From: Charlton Smith, President of the Stroudwater Farms Homeowners Association
To: The Portland Zoning Board of Appeals
Re: Conditional Use Application of Verizon Wireless dated October 21, 2015
Dated: February 1, 2016

Verizon Wireless has applied to the Zoning Board of Appeals for approval of a conditional use appeal to allow Verizon Wireless to construct a 1650 square foot equipment building with a large external diesel generator and other external equipment at 1877 Congress St.

1877 Congress Street, Portland - Proposed Verizon Wireless Commercial Building

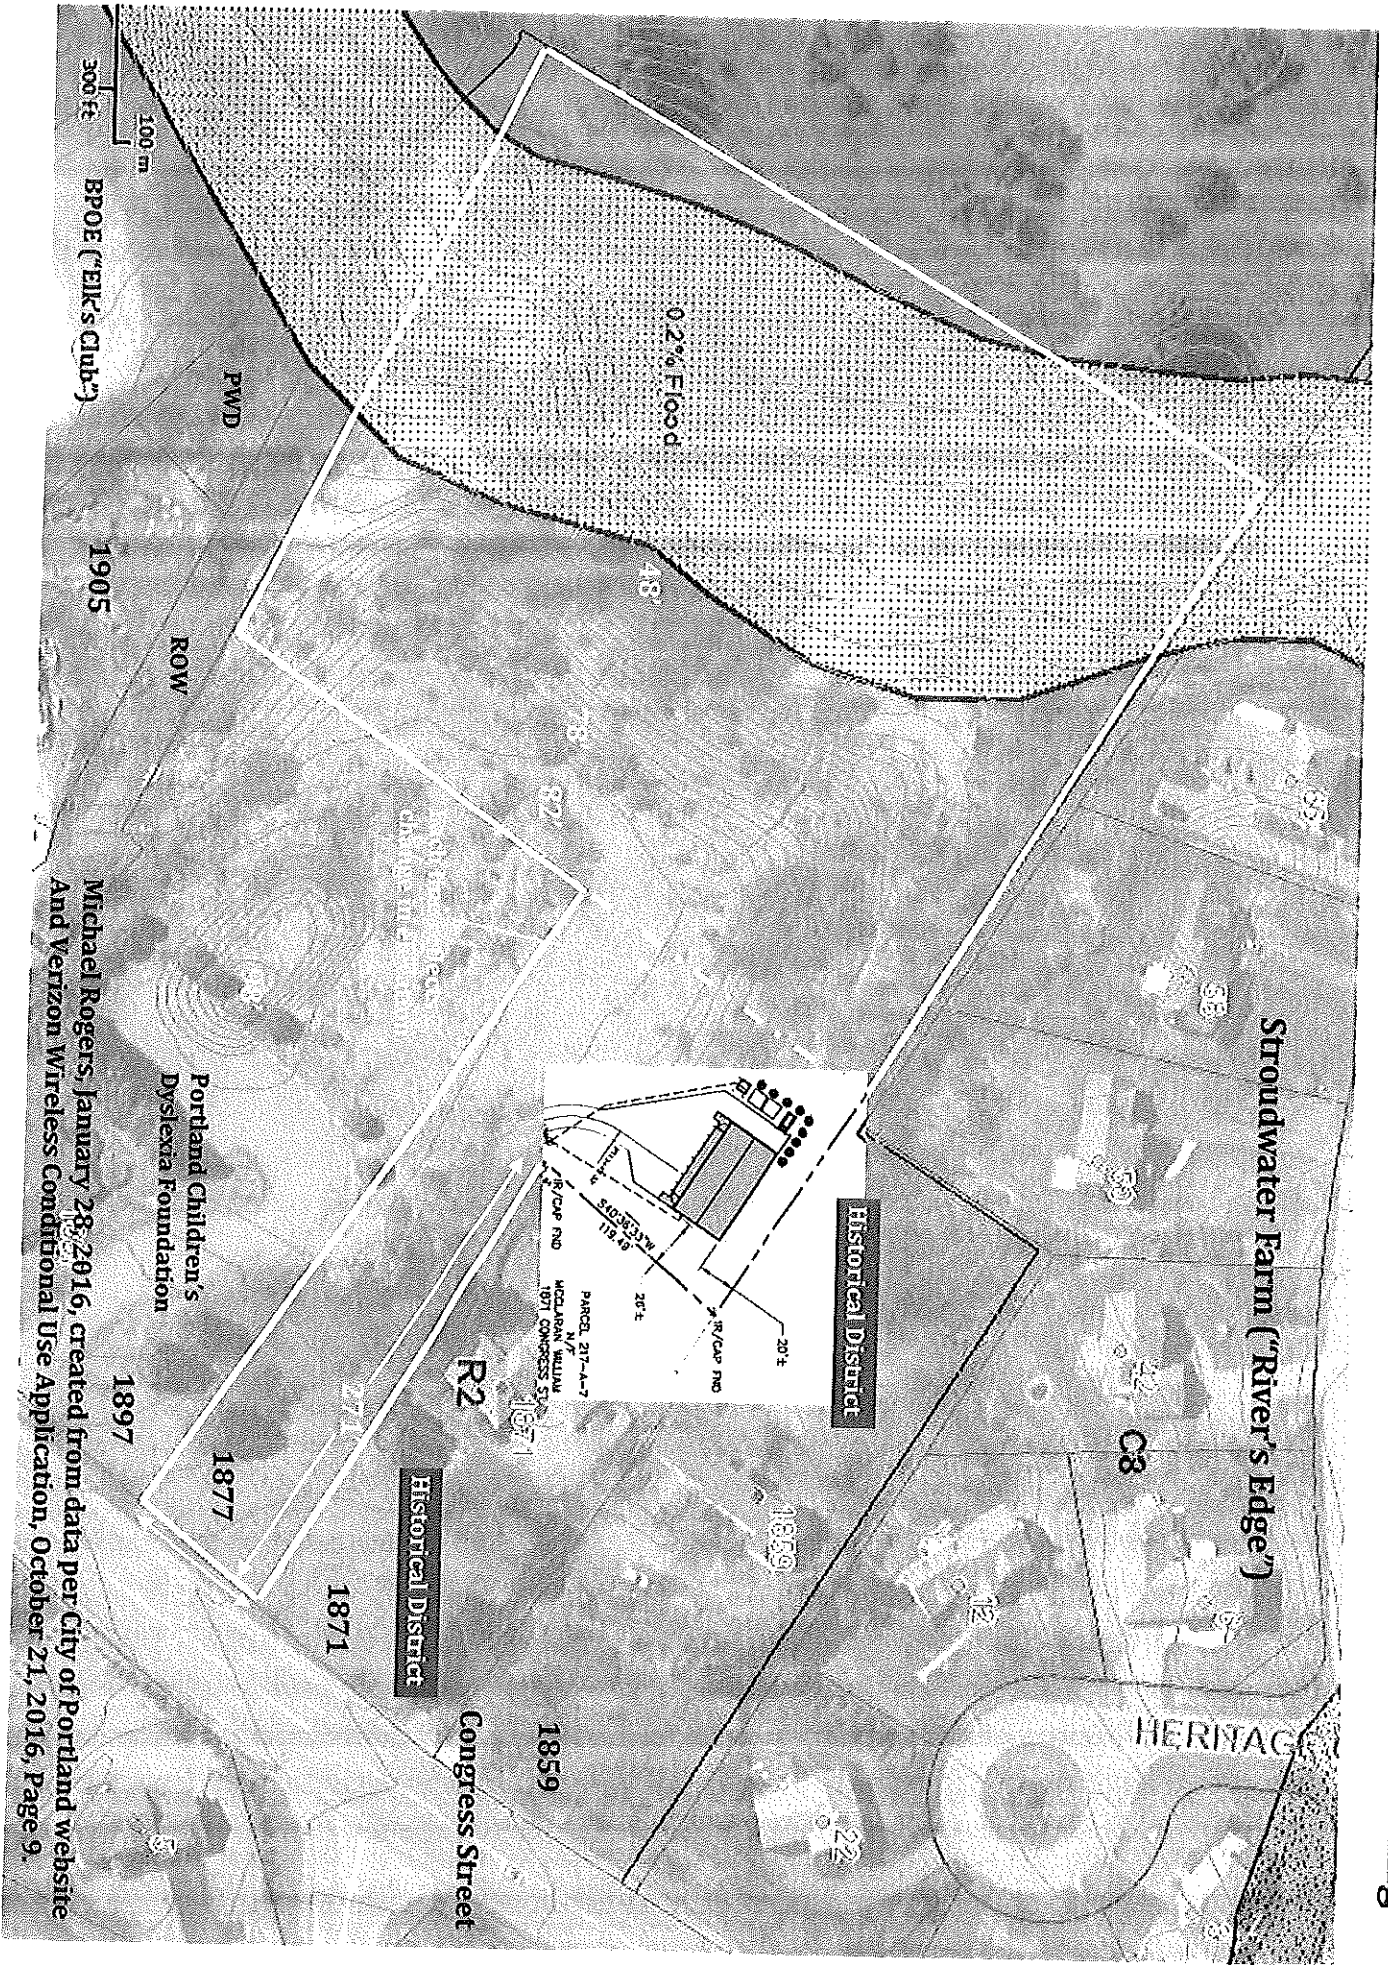
1. The Conditional Use Application (CUA) indicates that Verizon Wireless (VW) proposes “a wireless telecommunications facility” consisting of “a 1,650 square foot equipment shelter” accompanied by “an external generator on a 5 x 10 concrete pad”. The CUA indicates the type of Conditional Use proposed to be “utility substation/telephone electronic equipment”. The CUA provides site plots to indicate the proposed location of the building and the generator, which includes a designation of the facility as a “Head End” (undefined) facility. The site plan (CUA Sheets Z-1 and Z-2, note 17) refers to a tower to be located on the property.

- i. At the meeting on January 16th, VW representatives indicated that the plan will not include a tower or any other facilities outside of the proposed building for sending or receiving data. Please provide written confirmation that VW agrees as a condition of the application to preclude any such facilities and limit the mode of data communications to or from the facility to underground cables.

1. The proposed building should be moved 15 feet further from River's Edge in order to provide space to add two staggered rows of 12 foot high White Pines and Norway Spruce trees 8 feet apart on both the side and end of the building visible from River's Edge. Due to the extreme variability in quality of trees suitable for transplanting the trees should come from O'Donnell's Nursery in Gorham, Maine and be planted by a contractor approved by O'Donnell's Nursery. Being 12 feet high at the time of planting the trees will soon grow higher than the 18-foot roof peak. We were advised by O'Donnell's Nursery against using larger trees because if the trees are more than 12 feet in height transplanting is not as successful. Verizon Wireless would be responsible for making sure that these trees are properly cared for until they are fully established.

3. The diesel generator and all other exterior equipment related to the proposed facility presently shown on the plans will be relocated to the side of the building furthest from River's Edge to minimize its impact on the River's Edge neighborhood. The generator will not exceed 150 KW and will be inside a Level 2 enclosure. There will be no external antennas, satellite dishes, towers or any similar kinds of equipment used in connection with the building.
